From: Graeme Thorpe
Sent: 24 January 2012 10:16
To: Helen Booth
Subject: FW: Consultation on planning application 3/2011/0959 65 Whalley Road, Langho
Please print thanks

From: Hornby, Mark [mailto:Mark.Hornby@lancashire.gov.uk]
Sent: 23 January 2012 14:25
To: Graeme Thorpe
Cc: cguy.pearson@btopenworld.com
Subject: FW: Consultation on planning application 3/2011/0959 65 Whalley Road, Langho

Drawing 002

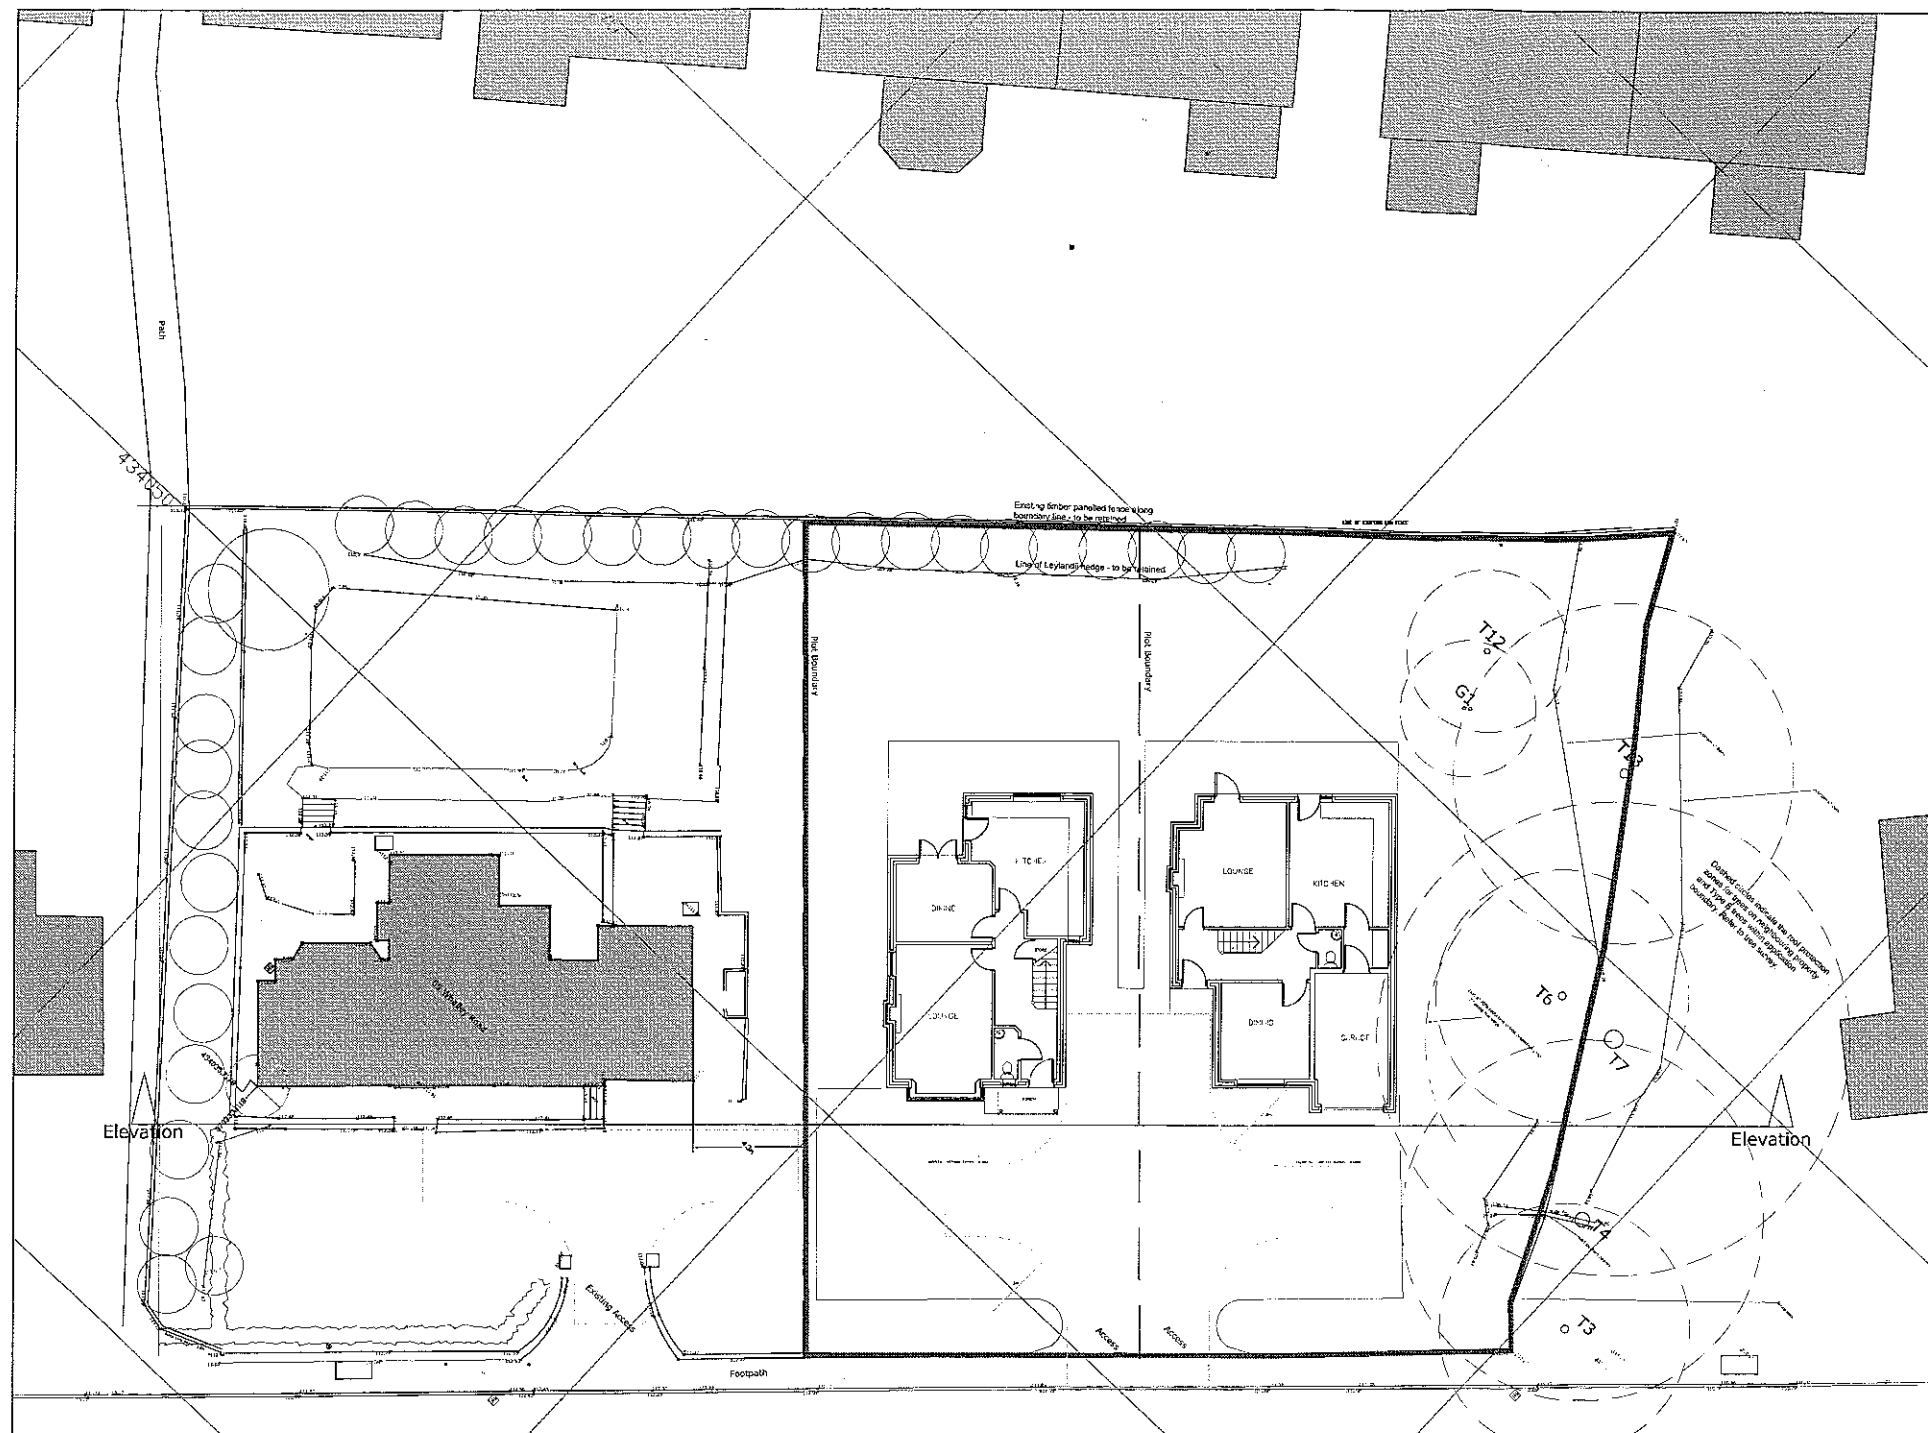
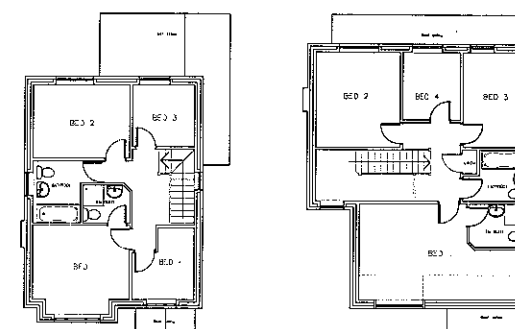
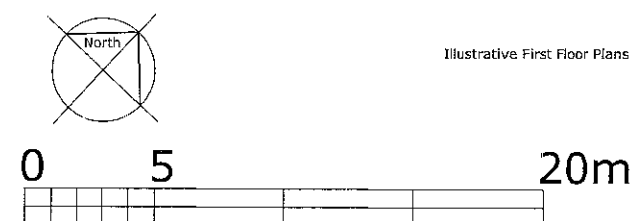
- 3 The layout of the development shall include provisions to enable vehicles to enter and leave the highway in forward gear and such provisions shall be laid out as shown on Drawing 002 or equivalent for each of the two new dwellings. A vehicular turning space shall also be provided to the front of the existing dwelling number 65 Whalley Road as shown on Drawing 002 or equivalent. These vehicular turning spaces shall be laid out and be available for use before the development is brought into use. Reason: Vehicles reversing to and from the highway are a hazard to other road users.
